Your ref:	147-149 Wardour Street (plant...	<b>Please reply to:</b>	<b>Mr Joshua Wilson</b>
Our ref:	23/07623/FULL	Tel No:	
		Fee Queries:	0207 641 6500;
		Email:	planningreception@westminster.gov.uk;
Mr James M 4D Planning 4D Planning 3rd Floor 86-90 Paul Street Hackney London EC2A 4NE		<b>Incomplete Applications</b> Town Planning & Building Control City of Westminster PO Box 732 Redhill, RH1 9FL	
			9 November 2023

**Address: 147 - 149 Wardour Street, London, W1F 8WD,**

**Proposal: Install external and roof-top plant and equipment and all associated works.**

Thank you for your application received on 2 November 2023. I am writing to inform you that your application is incomplete for the following reason(s):

**DRAWING TITLE**  
 Existing HVAC Layout  
 -Roof Top

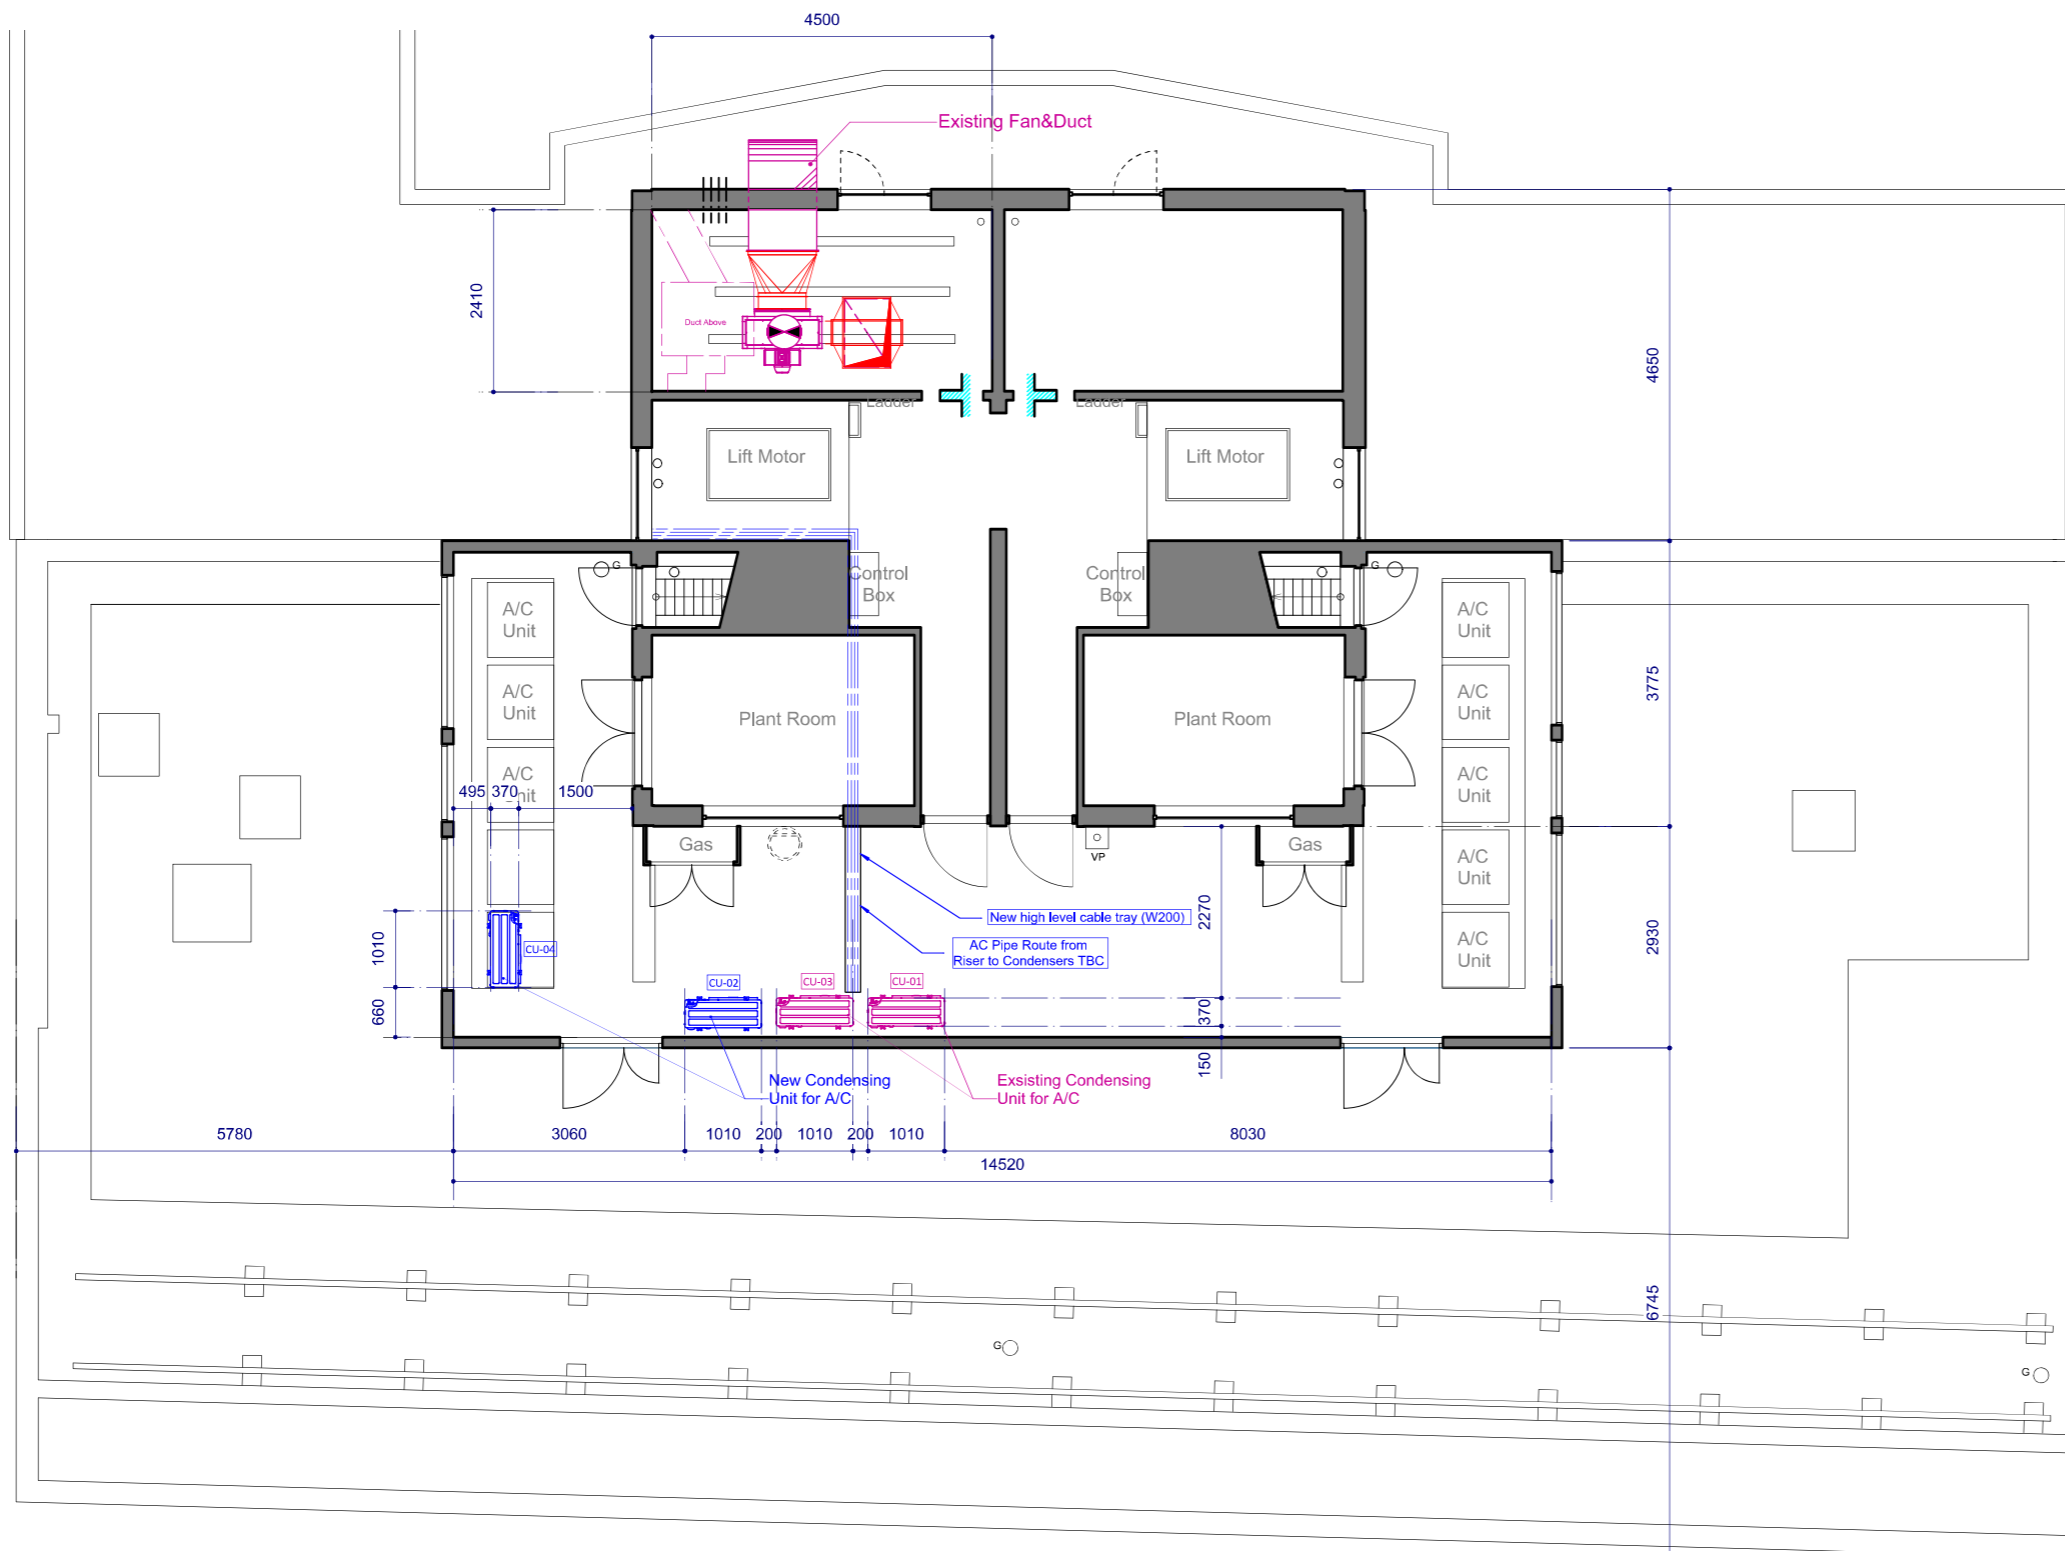
- 3 Please provide manufacturers specifications including technical data, size and colour of the proposed plant equipment.
- 4 Some or all of the drawings submitted with your application do not include a scale bar, please amend the drawings to ensure all drawings include a scale bar.
- 5 Please provide the following:

- existing roof HVAC Layout
